Loreto School

Concept Proposal and Stage 1 Development Application

Response to Submissions – SSD 7919

Part 1 - Response to Agency Submissions

Concept Proposal Envelope Elevation

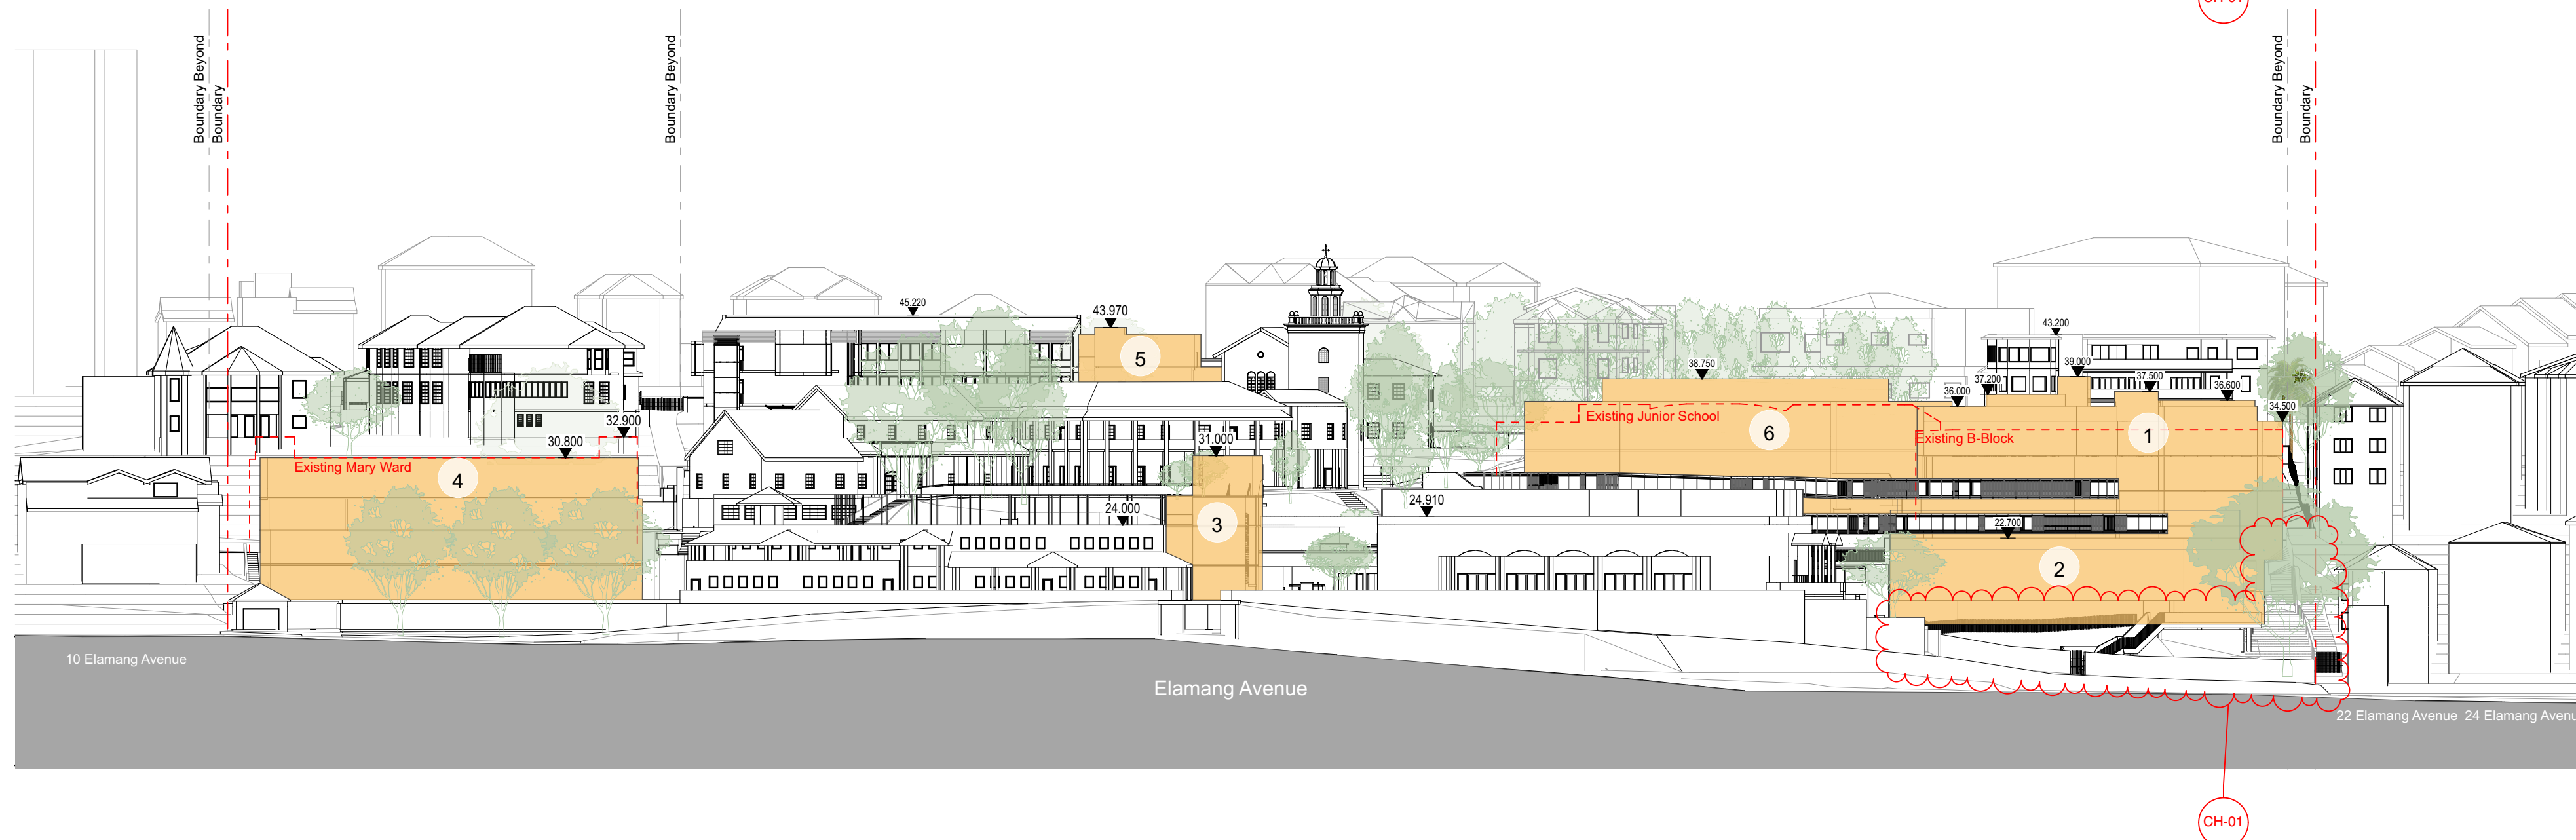
Issues Raised by Agencies and Organisations	Proponent's Response
<p>The concept building envelope within the eastern precinct is proposed to exceed the permissible height limit of 8.5m and would negatively impact on the views currently enjoyed by the residents on the southern side of Carabella Street and adjoining the eastern boundary of the site. The existing building only exceeds the permissible building height at two locations whereas the entire building footprint of the proposed concept envelope would exceed the permissible height limit. Insufficient information has been provided to justify the height exceedance. It is considered that the height of this concept envelope should be reduced to comply with the permissible height limit of 8.5m or be consistent with the height of the existing building.</p>	<p>Noted. In response to the issues raised, the development envelope in the Eastern Precinct has been reduced to be consistent with existing height of the Mary Ward at RL 29.940. Revised plans for which approval is now sought are provided at Appendix B.</p>

- North Sydney Council is of the view that the scale of the New Buildings particularly the new additions to the western building (Learning hub) located close to the adjoining boundary site are incompatible with the site's adjoining and opposite along Carabella Street and Elamang Avenue. Existing buildings at the eastern end of the sites are zoned R2 Low Density Residential with a maximum permissible building heights of 8.5 m.

In response to the issues raised, the envelope in the Eastern Precinct has been reduced in height to align with the height of the existing Mary Ward.

Stage 1 Envelope Elevation

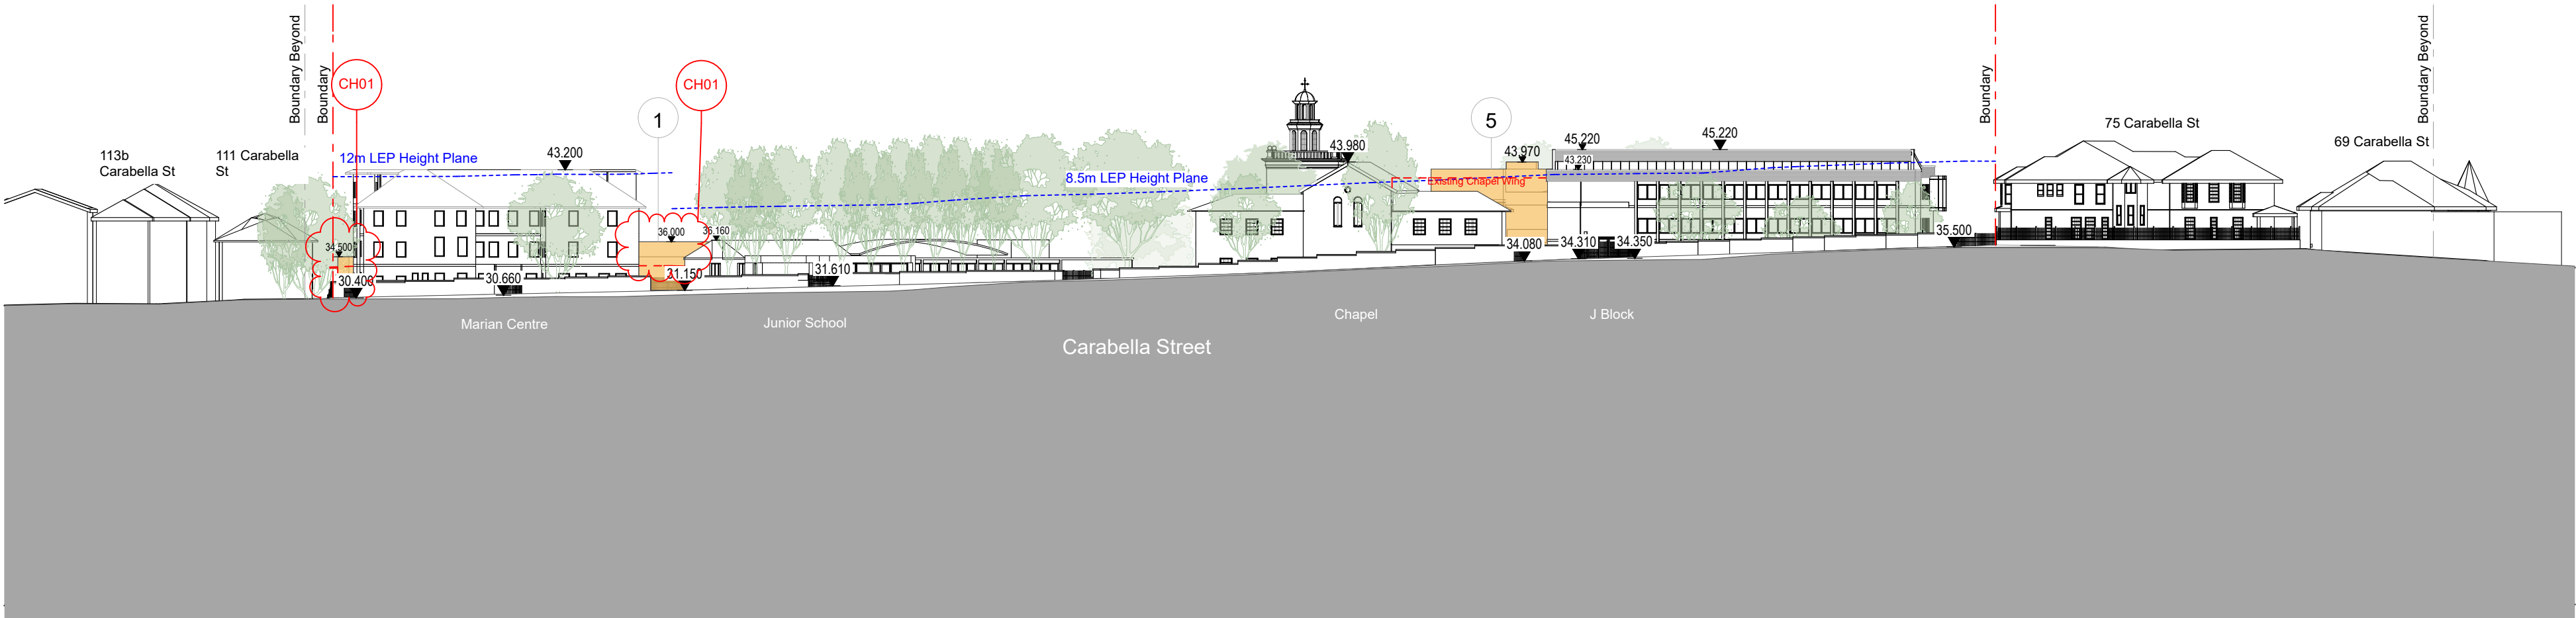
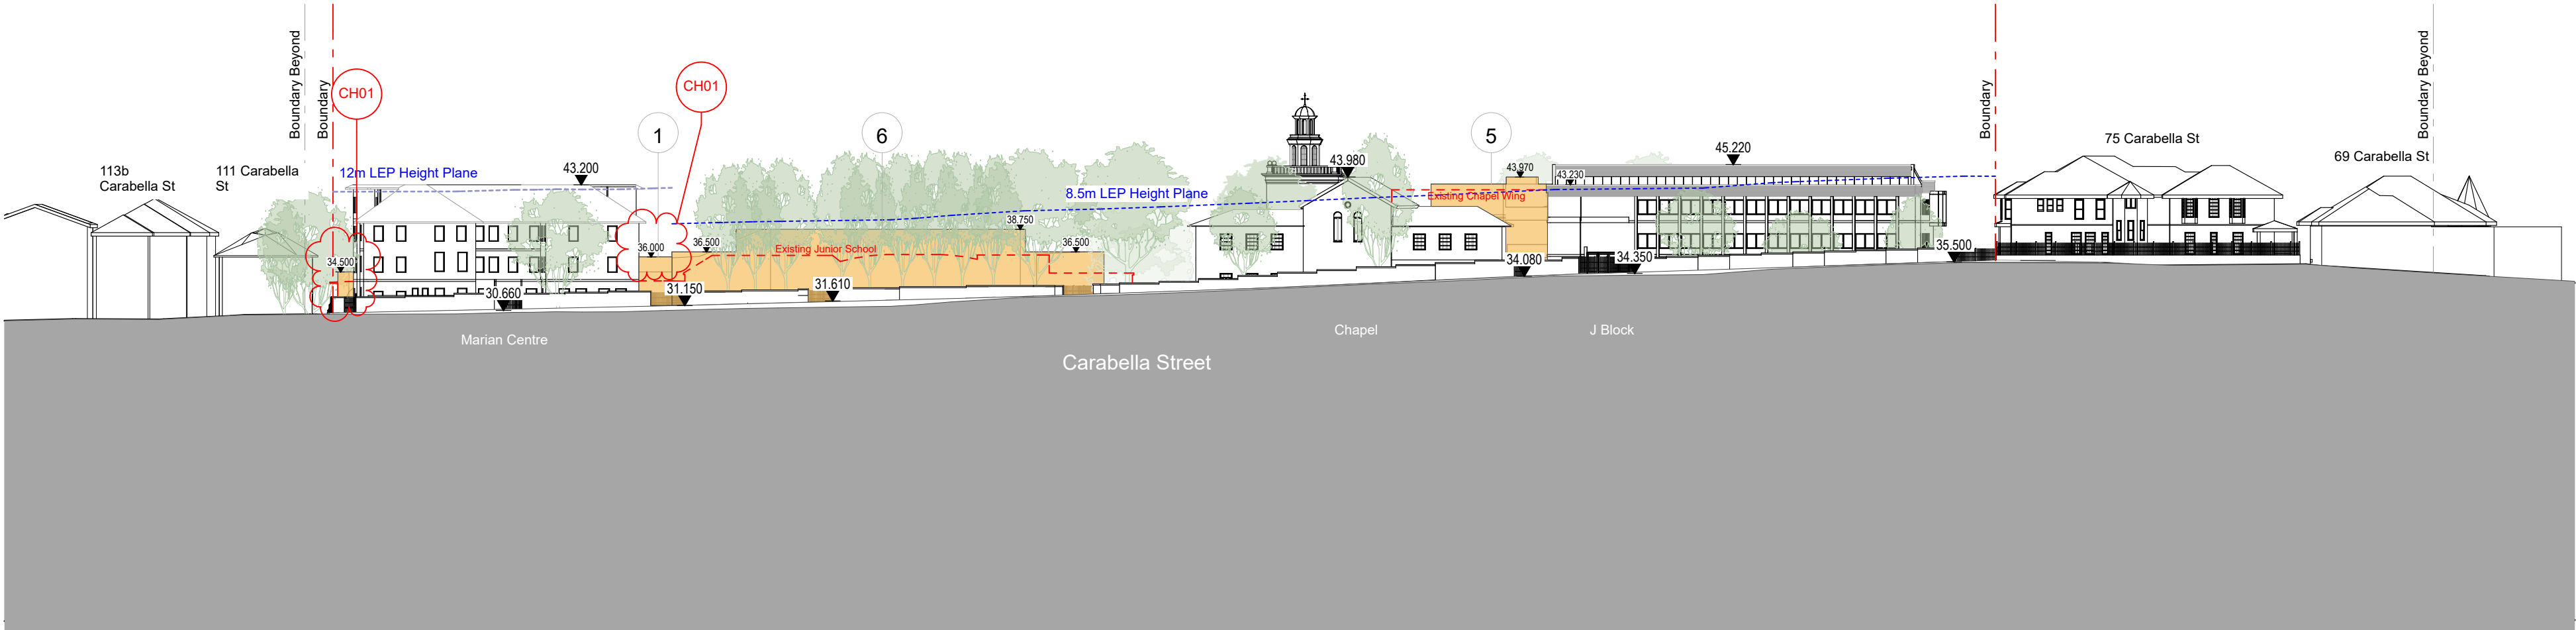
<p>The EIS does not include details of the use of the roof terrace located above the learning hub on the western precinct. An assessment of the acoustic impacts related to such usable has also not be undertaken.</p>	<p>The original intent of the roof top terrace was to provide a landscaped outdoor learning area and horizontal connection between the Learning Hub and adjacent Marian Centre Building. This was in alignment with the project specific design principles and Principle 1 of the Education SEPP. Following the community consultation, design</p>

Issues Raised by Agencies and Organisations	Proponent's Response
	<p>and operational changes were investigated to improve the visual amenity and acoustic impacts of the rooftop terrace for the adjacent neighbours.</p> <p>In order to reduce the acoustic impact, address privacy concerns and improve the outlook for the adjacent neighbours, the outdoor learning area was removed and replaced by an extended roof garden. The intended use of the rooftop terrace has been limited to enable connectivity between the Learning Hub and the Marian Centre and to allow intermittent staff and student access to the rooftop garden for maintenance. The roof garden may occasionally be used as a supervised recreation space.</p> <p>Further to the above changes, the plant equipment was reduced in size and redistributed to alternative locations, maximising the area of the roof garden. The remaining plant equipment was relocated to the least visible location when viewed from 111 Carabella Street.</p> <p>The circulation path providing the connection between the two buildings has been set back as far as possible from the boundary (15.5m) and a planter has been integrated into the western facade to provide a landscaped buffer between the adjoining properties. Improving accessibility and way finding, and the integration of the landscape, are key components to the identified design principles of the Masterplan. The above amendments have enabled the achievement of these principles whilst minimising the acoustic impacts and improving the outlook for the adjacent residents.</p>
